From:
Sent: 22 June 2026 10:59
To: DC Admin
Subject: 2026/CLD/91507/E OBJECTION

I am writing to formally object to the planning application referenced above. I live at 5 South Brook Gardens which is close to the proposed site. I believe this conversion will harm our residential area for the following reasons:

SITE PLAN 1:100

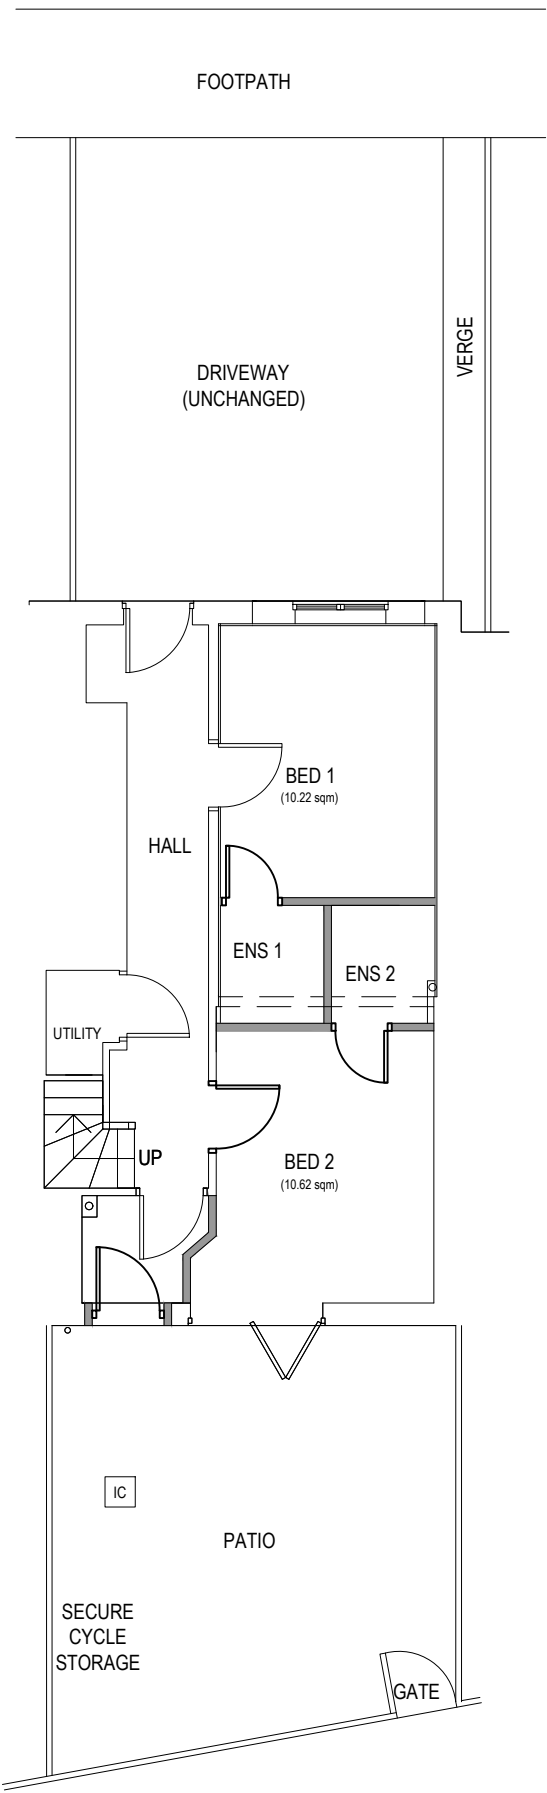
Inadequate Parking and Highway Safety: Our street is already heavily congested with vehicles. A standard family home typically has one or two cars, but an HMO can lead to significantly more vehicles parked on the street. The applicant has not provided enough off-street parking spaces. This will force cars onto pavements, block driveways, and create hazards for pedestrians and emergency vehicles.

Waste Management and Hygiene Issues: An influx of unrelated residents will generate a large volume of domestic waste and recycling. The front of the property lacks the physical space to store the necessary amount of extra bins. This will lead to bins blocking the footway, unsightly litter, and pest issues, which harms the character of the street.
